Application Ref:	3/2021/0049	 Ribble Valley Borough Council www.ribblevalley.gov.uk
Date Inspected:	N/A	
Officer:	RB	
DELEGATED ITEM FILE REPORT:		PERMISSION NOT REQUIRED

Development Description:	Proposed Construction of a new detached single garage
Site Address/Location:	Homeacre, Lovely Hall Lane, Copster Green, BB1 9EQ

Proposed Front Elevation
(Scale 1:100)

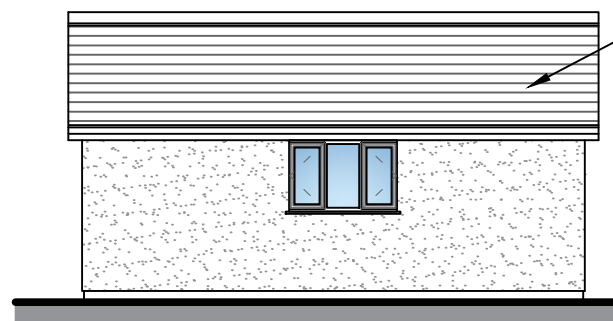
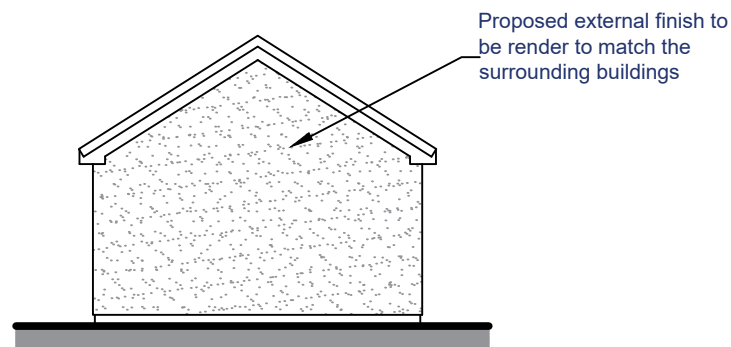
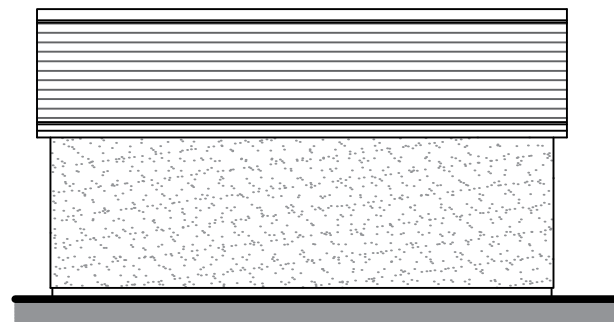
The proposed outbuilding will be single storey.

The proposed outbuilding will have a pitched roof measuring 3.83m in total height.

The outbuilding will not exceed 2.5m in total height to the eaves

Location Plan
(Scale 1:2500)

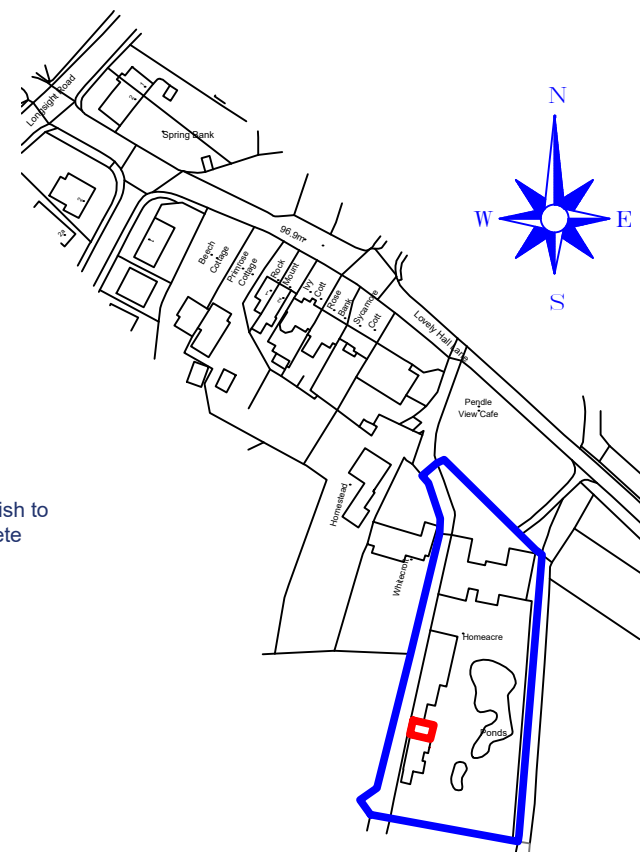
The outbuilding is sited to the rear of the dwelling.
